**PERSIMMON HOMES
NORTH LITTLEHAMPTON PHASE 1
TODDINGTON LANE S278 WORKS**

**ROAD SAFETY AUDIT RESPONSE
REPORT TO STAGE 1 RSA ADDENDUM**

MAY 2016

Project Code:	PHLITTLE.2/IDR-DR
Prepared by:	AB
Approved by:	SW
Issue Date:	3 MAY 2016
Status:	1st ISSUE

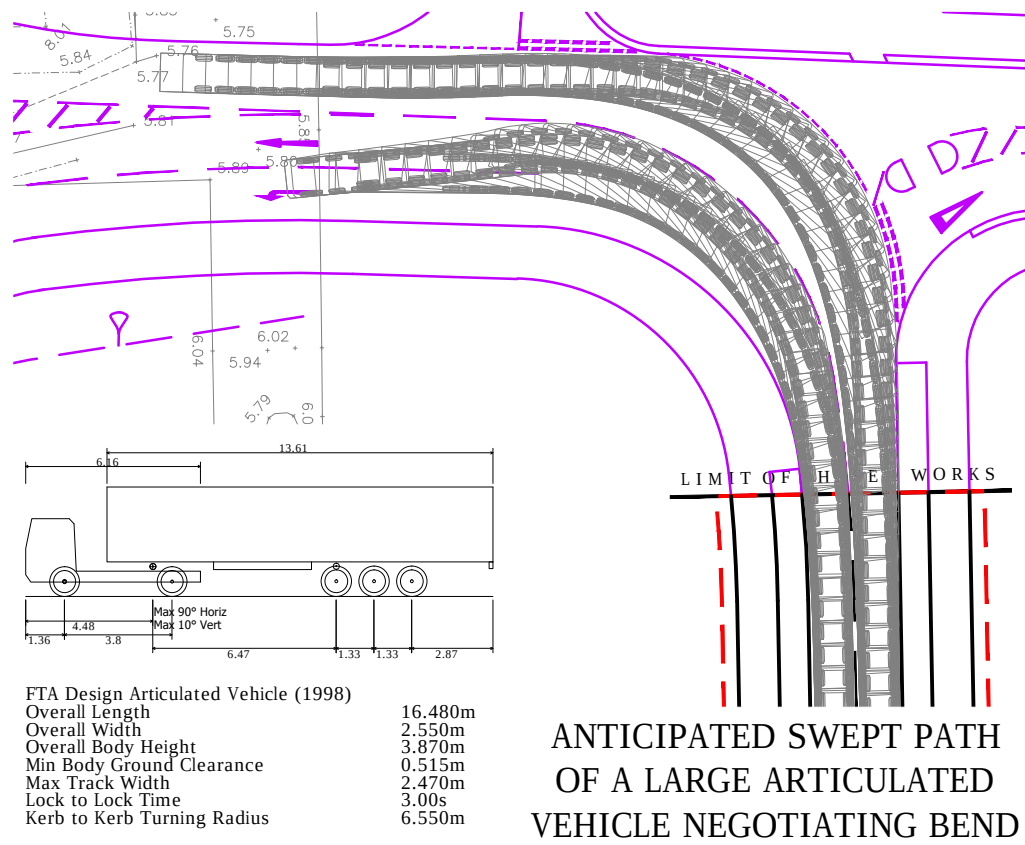
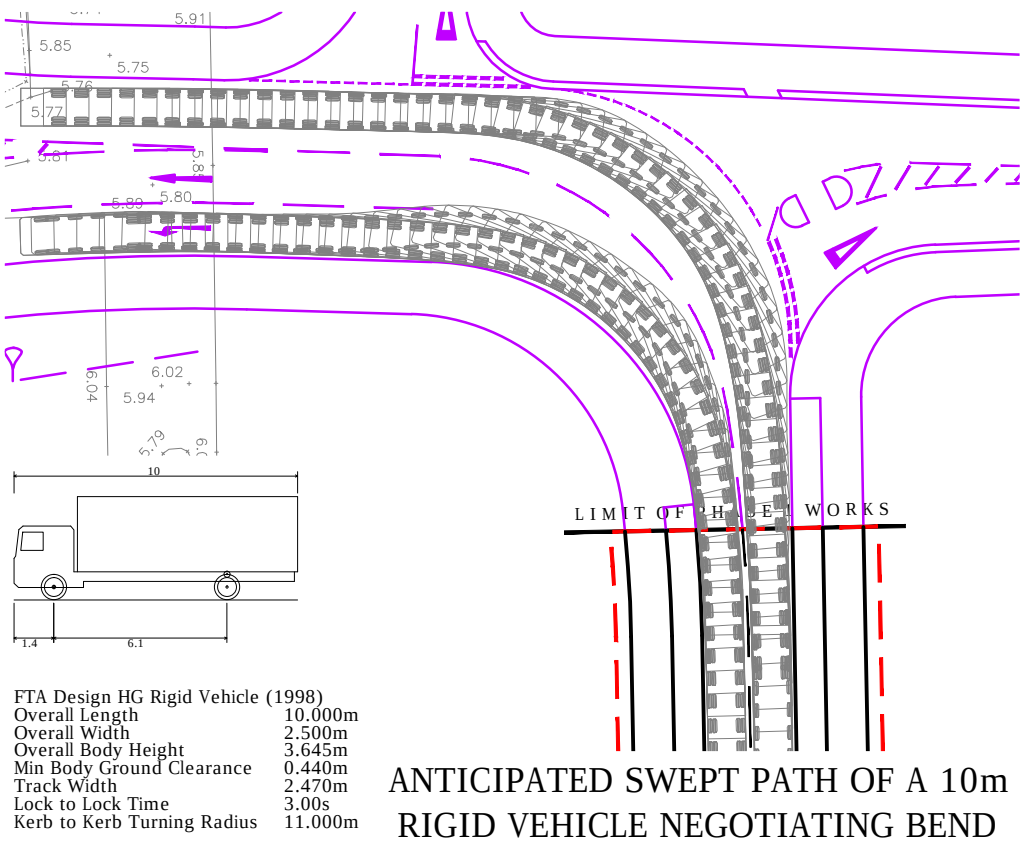
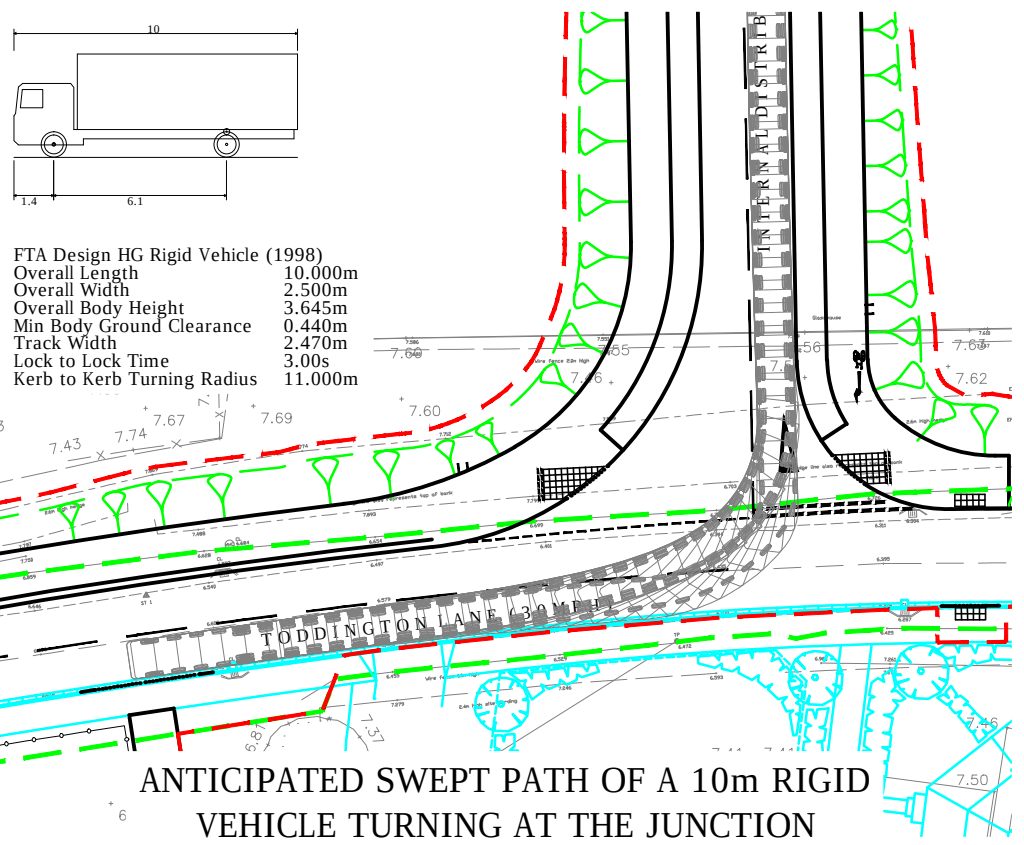
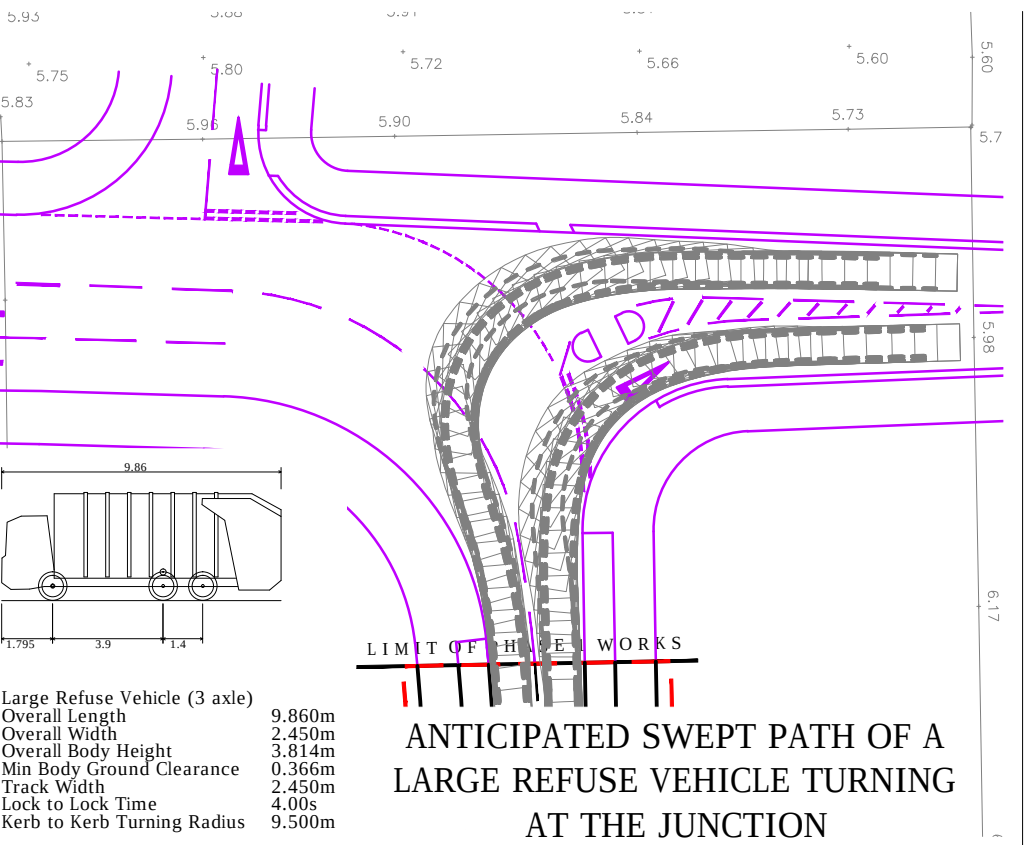
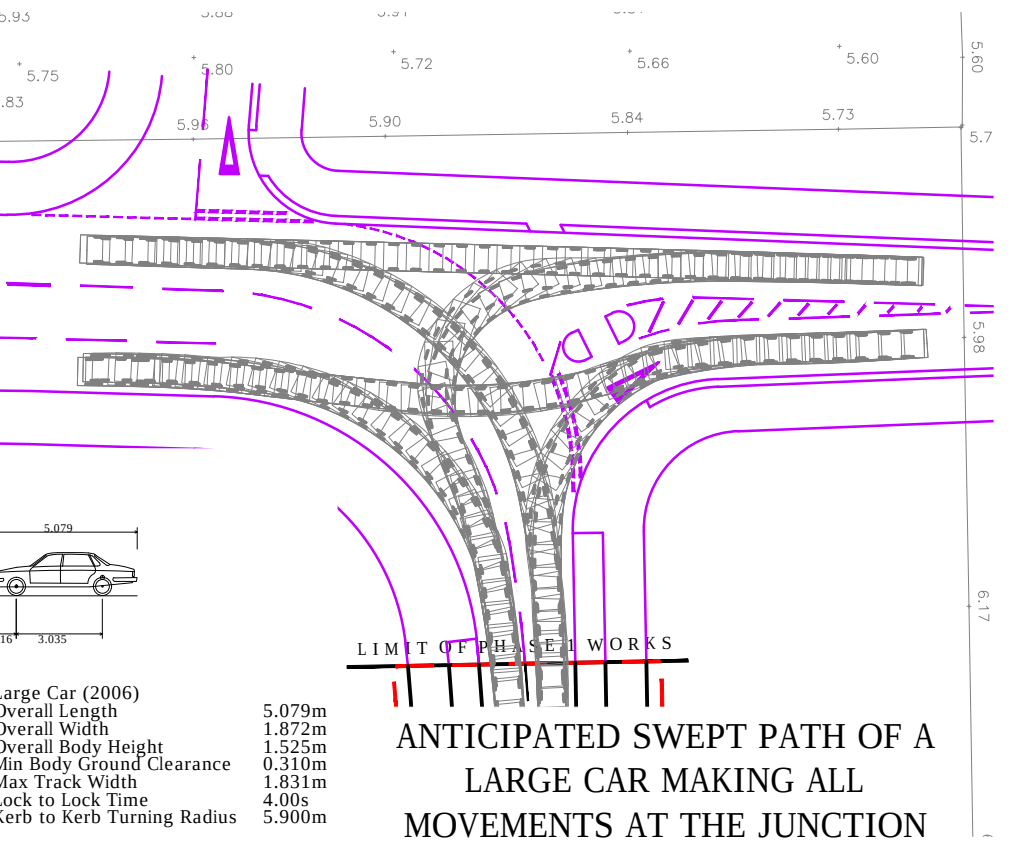
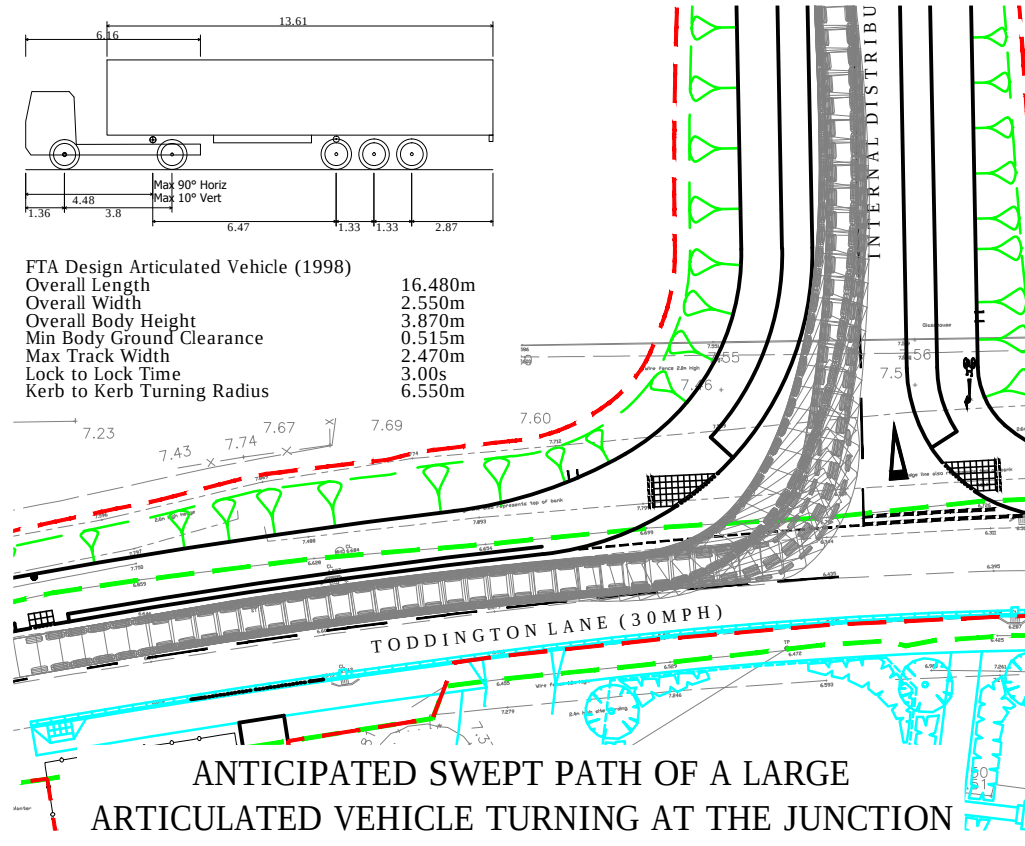
The drawing shows a 20m kerb radius on the west side of the junction. This could encourage relatively high speeds by left-turning vehicles, particularly cars and light vans, and it increases the width of carriageway to be traversed by pedestrians crossing the junction; both of these factors increase the danger to pedestrians from turning vehicles. Whilst it appears from the traffic flow information supplied in the Audit Brief that a significant number of HGVs will use this junction, it is clear from the swept path plots that the radius could be reduced without causing them difficulty.

- i. Reduce the kerb radius as far as possible consistent with providing adequate turning space for the largest vehicles regularly using the junction.
- ii. Inset the pedestrian crossing point slightly further into the junction (c.1.5m) to reduce the crossing width for pedestrians, particularly those with a disability, and increase their visibility to/from southbound vehicles approaching on the IDR.

Whilst the shared path provision should increase cyclists' safety by removing them from the carriageway, this benefit is likely to be largely nullified by the frequent interruption of the route by side road junctions where cyclists are not given priority; in these circumstances, although children may cycle along the path, confident cyclists are more likely to remain in the carriageway to avoid the possible need to keep stopping. In addition, the side road junctions are drawn with 8m kerb radii, which will not significantly reduce turning vehicle speeds to maximise the safety of pedestrians and cyclists. In accordance with Manual for Streets advice it would be better in most cases to keep kerb radii to a minimum and accept that larger vehicles will occasionally need to cross into the opposing lane of the IDR to make the turn. The Auditors have not been provided with details of the individual development areas to be served off each side road, but in some cases (i.e. if only a small number of dwellings is proposed) it may be appropriate to provide access in the form of a dropped kerb and footway crossing rather than a kerbed bellmouth. Alternatively it may be appropriate to provide entry treatments such as entry ramps, raised tables and/or set back Give Way markings.

Reconfigure the side road junction treatment (providing cycle priority if possible) to improve continuity of the cycle route.

- (i) Accepted. Kerb radius reduced, as recommended, by the provision of a compound kerb.
- (ii) Accepted. Crossing point inset 1.5m further as recommended.

Accepted. Junction radii were initially indicated to be 6m but WSCC requested via comments dated 11 Feb 2015 that we consider increasing them. Subsequently, the radii were increased to 8m. However, the radii have been reduced back to a minimum of 6m as recommended. As set out in the Auditor's summary, this will require larger vehicles such as the occasional refuse vehicle to cross into the opposing lane to make the turn, although this would have happened with the 8m radius as well.
